From: Mike Burford
Sent: 07 February 2012 17:07
To: Planningecons
Subject: RE: Planning Consultation on: AB/8/12/
[Engineers comments on AB/8/12/](#)

APPLICATION AB/8/12/
NO:

Registered: 01-FEB-12
Site Land adj 84 Maltravers Street Aundel BN18 9DS
Address:

Description of Works: Erection of 1 no. new dwelling

Lower Ground Floor

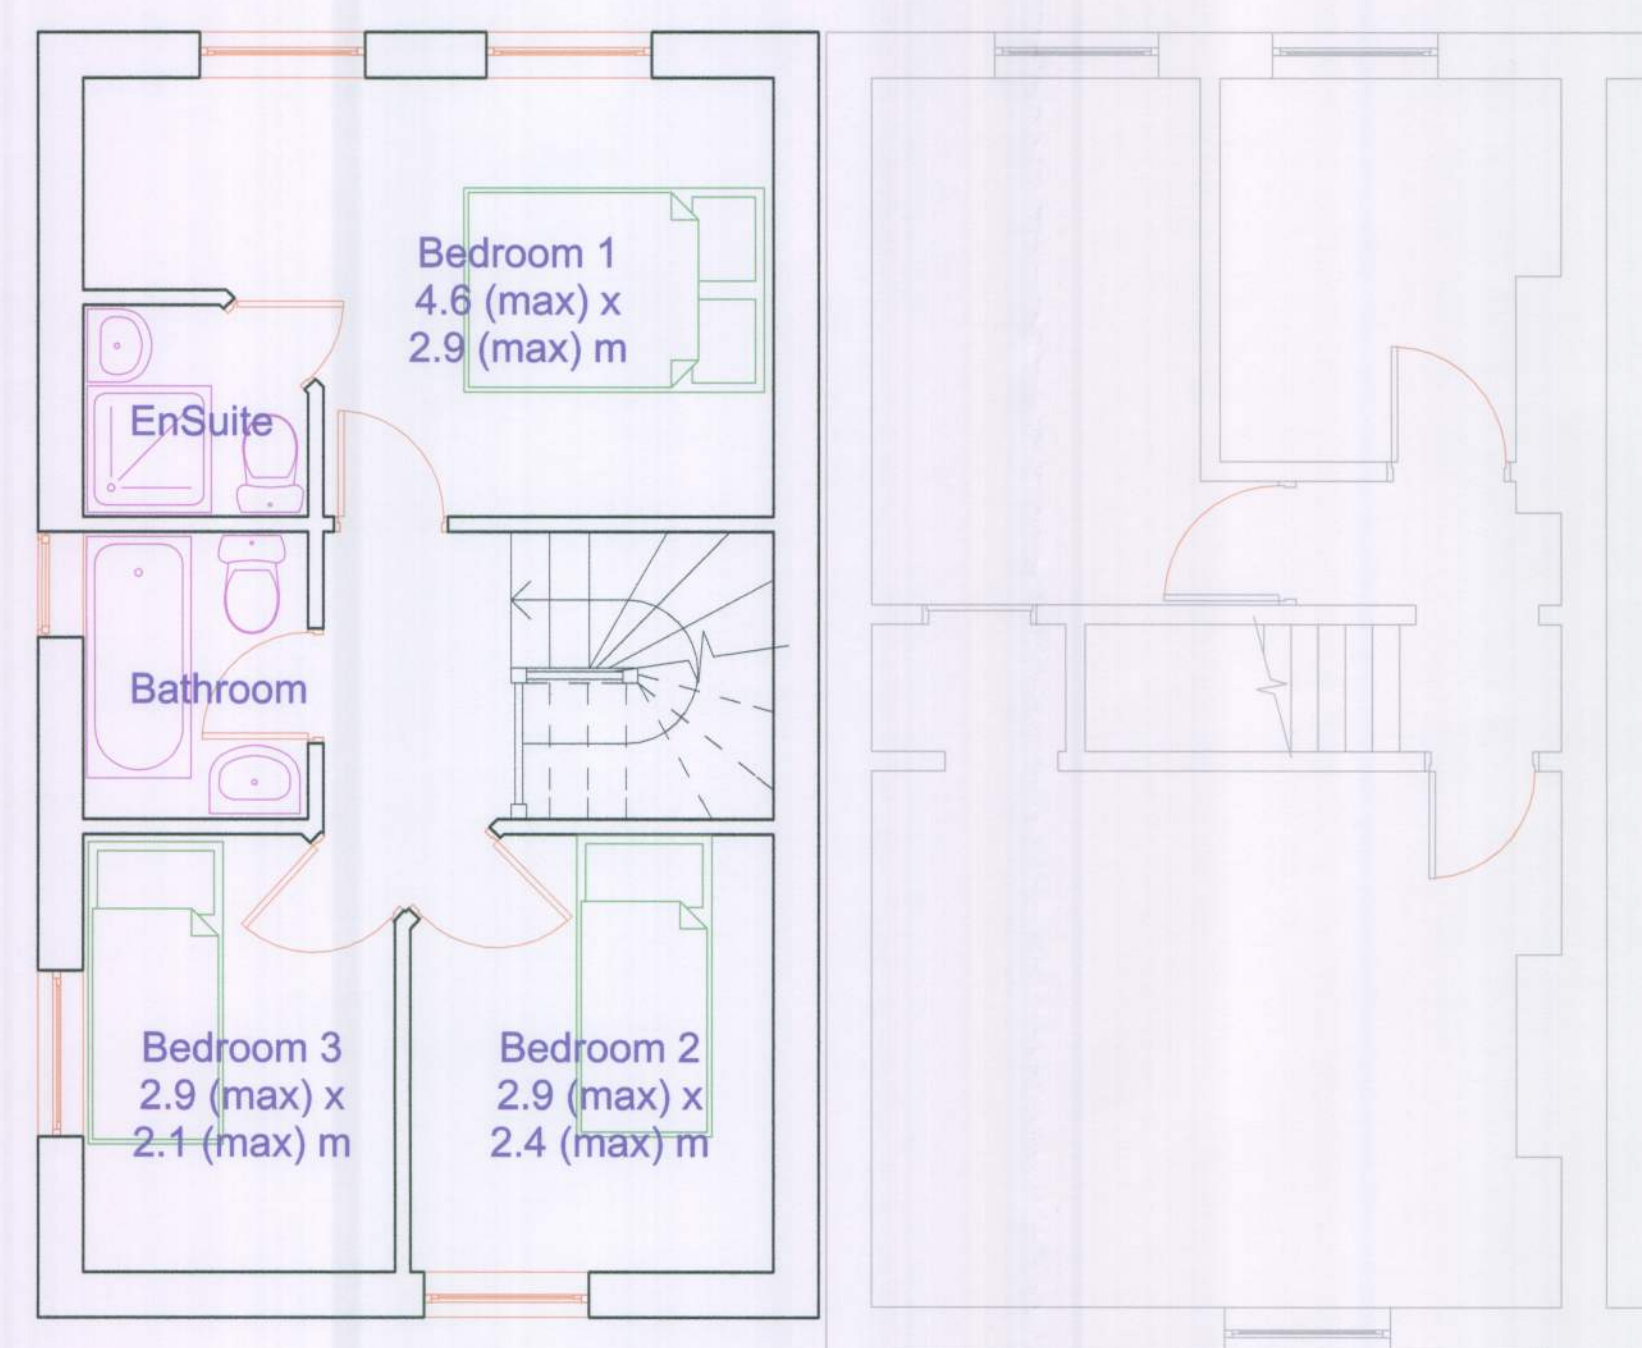
The proposed building is over or very close to a foul and surface water sewer. To build this close to the sewer the applicant would require permission from Southern Water.
